Application for a Non-Material Amendment Following a Grant of Planning Permission

Construction of a single storey rear extension with part first floor extension (including loft conversion with gable end) and conversion of the garage to a habitable room and associated external works (re-consultation - amended description of development).

23/3653/HD

DATE : 2023.10.12
 DRAWING No: P1.8
 DRAWING TITLE : PROPOSED REAR ELEVATION
 SCALE : 1:100@A3

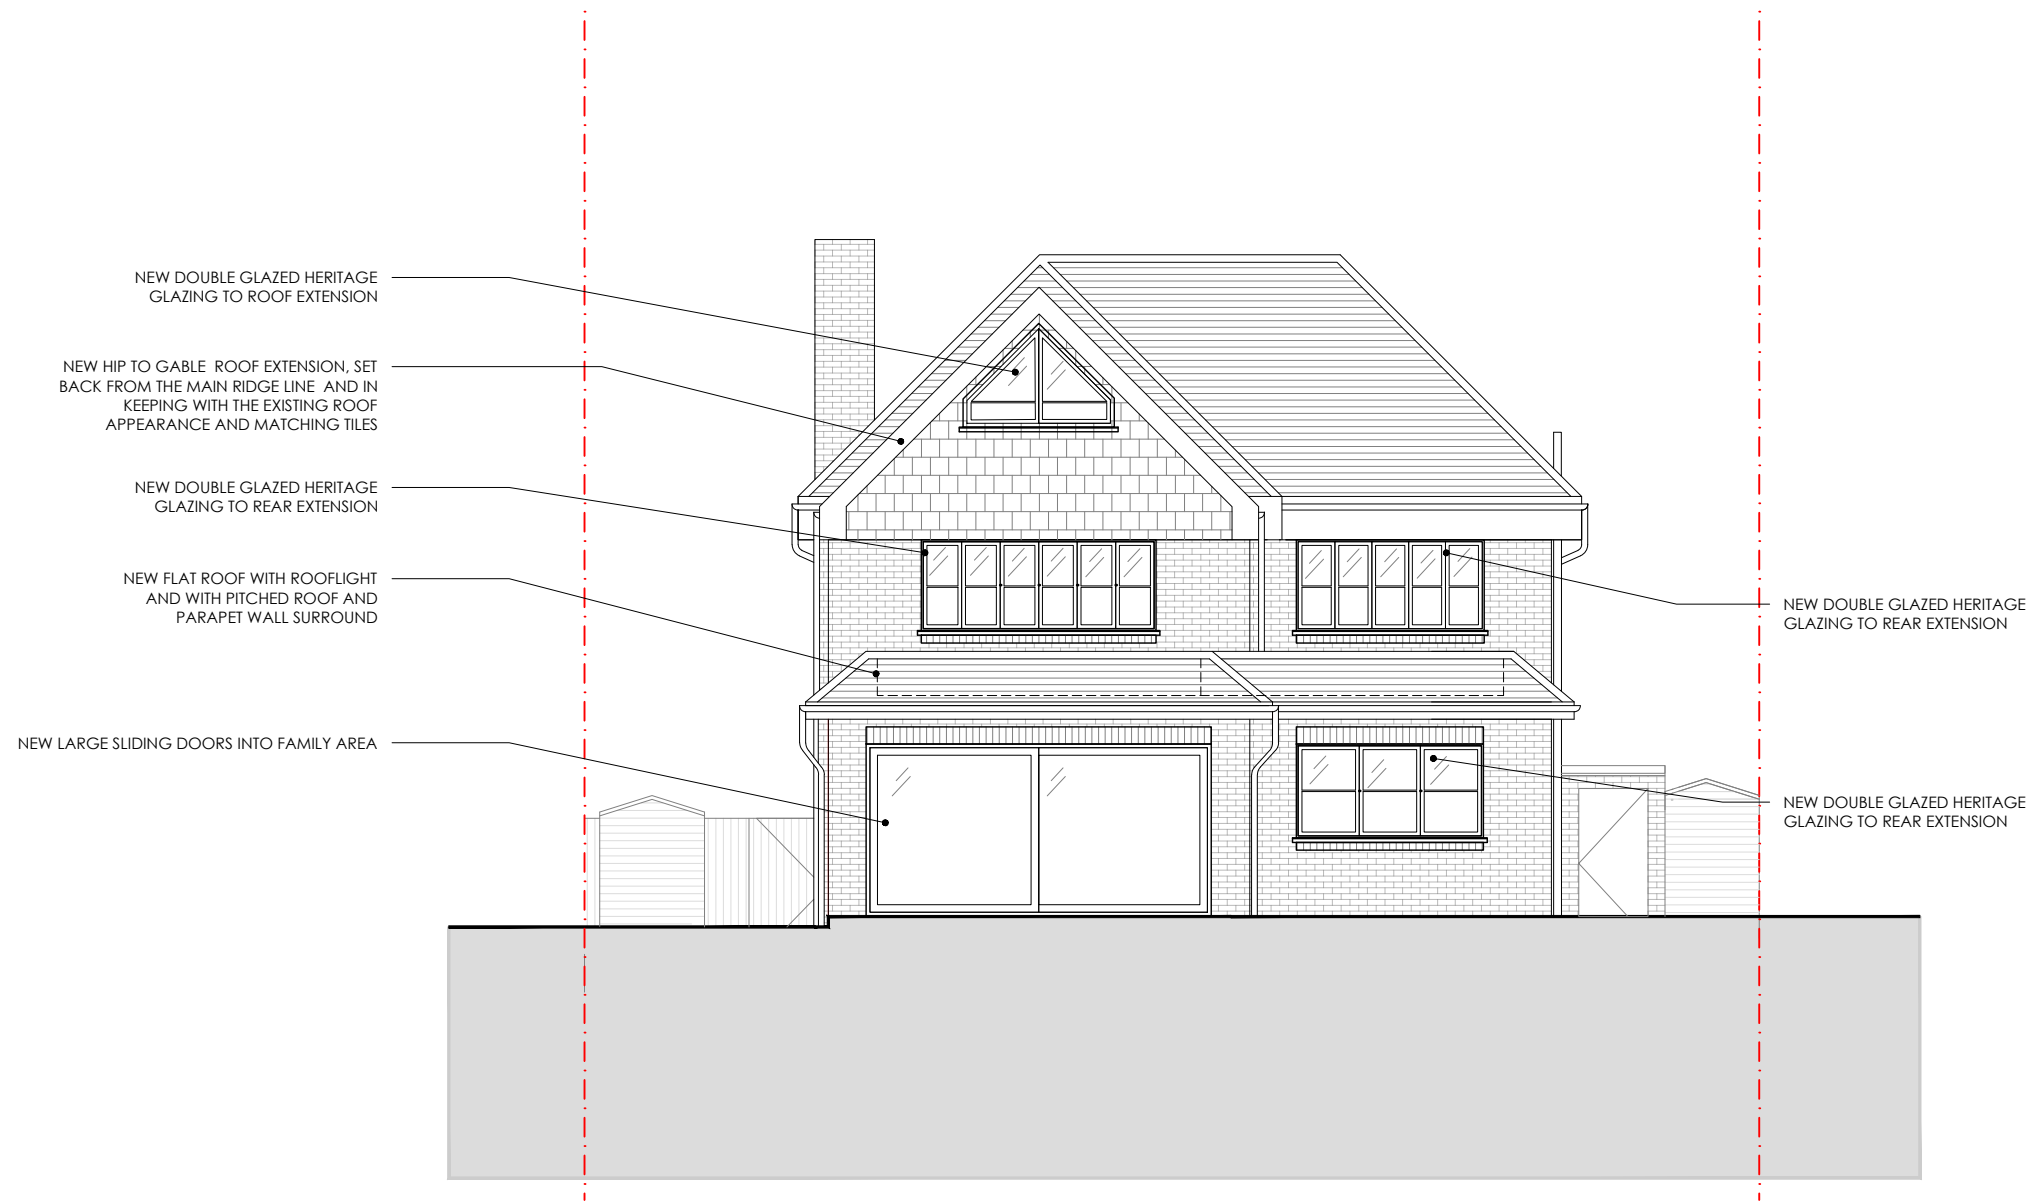
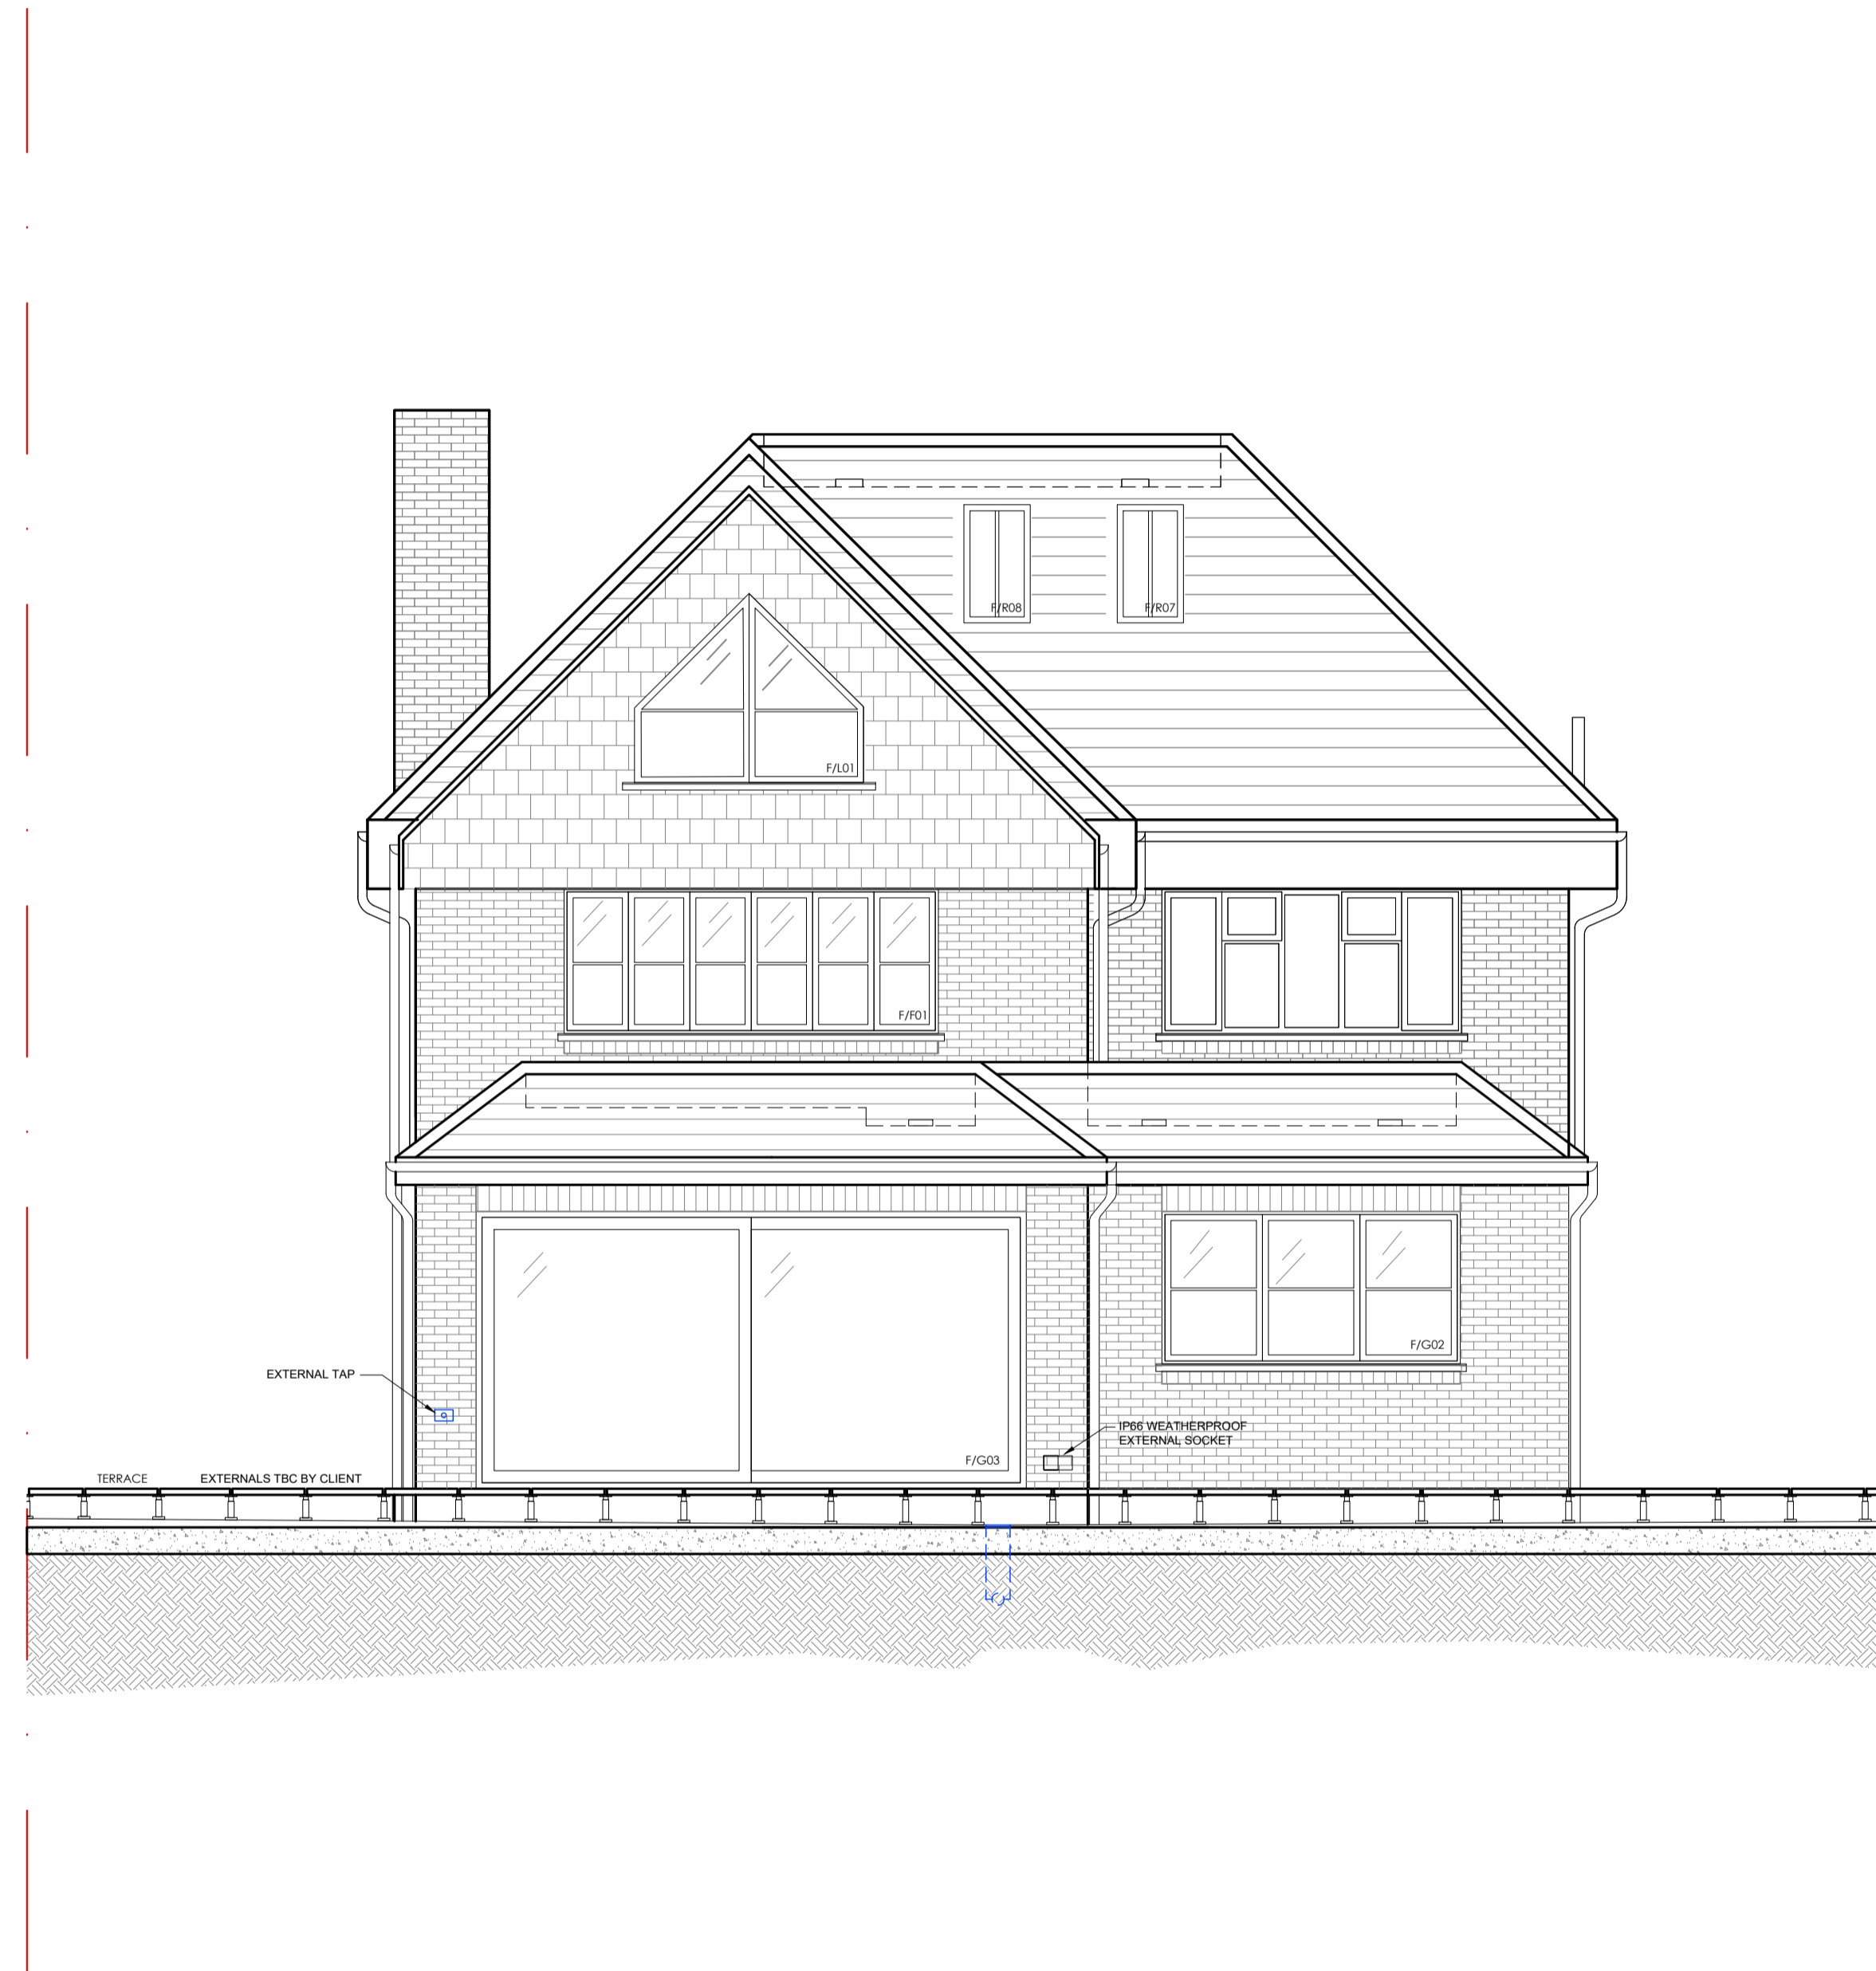
2 no additional conservation roof lights in existing rear roof slope

To achieve natural lighting within the converted loft area.

P1.3 Proposed Loft Plan
P1.4 Proposed Roof Plan
P1.8 Proposed Rear Elevation

C33 Proposed Loft Plan
C34 Proposed Roof Plan
C36 Proposed Rear Elevation
